January 20, 2022

Re: Brio Sandia Apartment
11930 Menaul Blvd. NE
Traffic Circulation Layout
Architect's Stamp 12-17-21 (H22-D029)

Based upon the information provided in your submittal received 01-14-22, the above referenced plan cannot be approved for Building Permit until the following comments are addressed:

WALL -SECTION
SCALE: 3/4" = 1'-0"

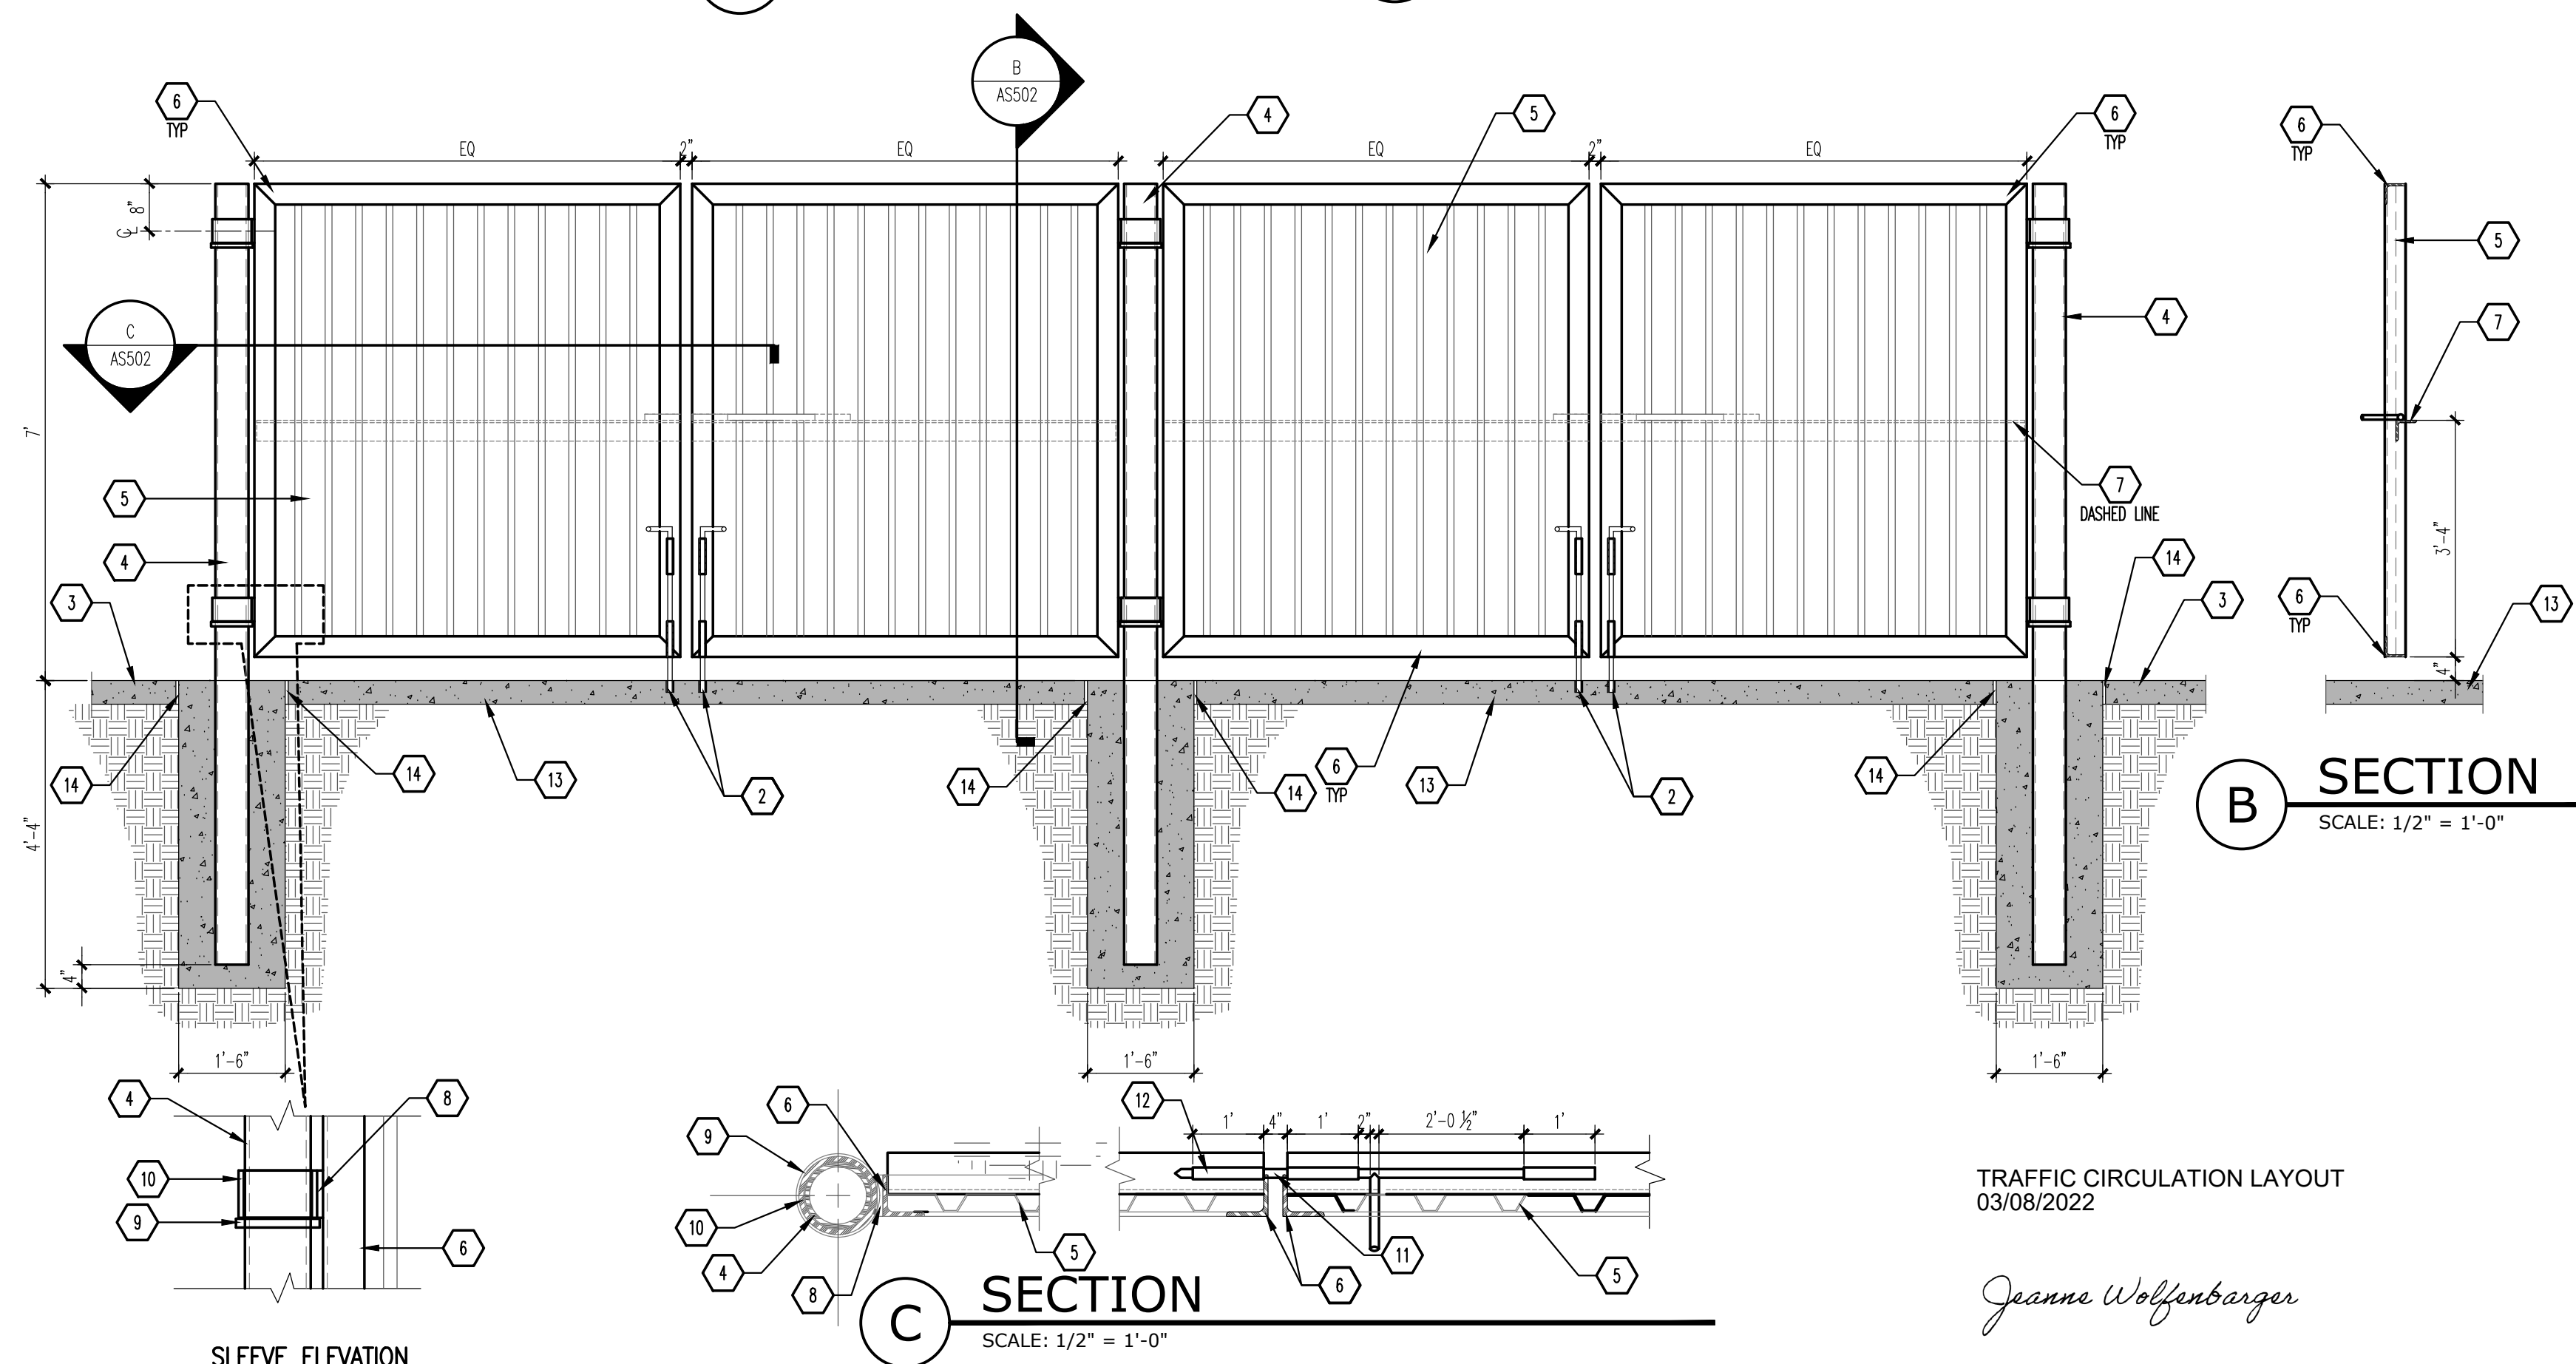
5. Motorcycle parking spaces shall be designated by its own conspicuously posted upright sign, either free-standing or wall mounted per the zoning code.

11. Provide face sign details for Motorcycle and for "DO NOT ENTER" sign.
 12. Add a note stating "All broken or cracked sidewalk must be replaced with sidewalk and curb & gutter." A build note must be provided referring to the appropriate City Standard drawing.
